Final Report - Corrections Required **Application No. ANEX-24-0002**

Description : Matrix Design Group on behalf of Colorado Springs Equities LLC is submitting a serial annexation petition for seven parcels and Land Use Plan/Rezoning exhibit for a portion of the subdivision known as Rock Creek Mesa.

Document Filename : Petition for Annexation_Addition 2.pdf

[ROCK CREEK MESA ANNEXATION FILING NO. 2]

ROCK CREEK MESA ADDITION NO. 2

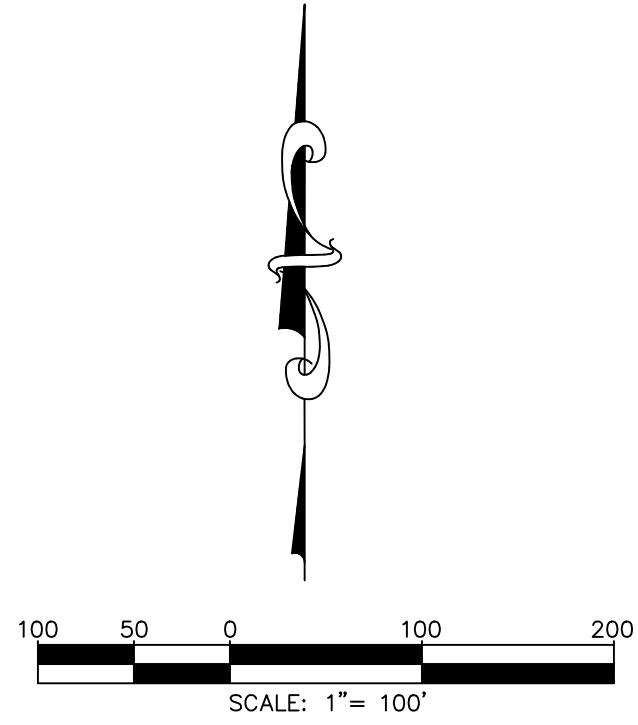
Comment ID	Page Reference	Reviewer : Department	Review Comments
25	1	Gabe Sevigny : Planning	Verify that any comments on the Legal Description is also updated here
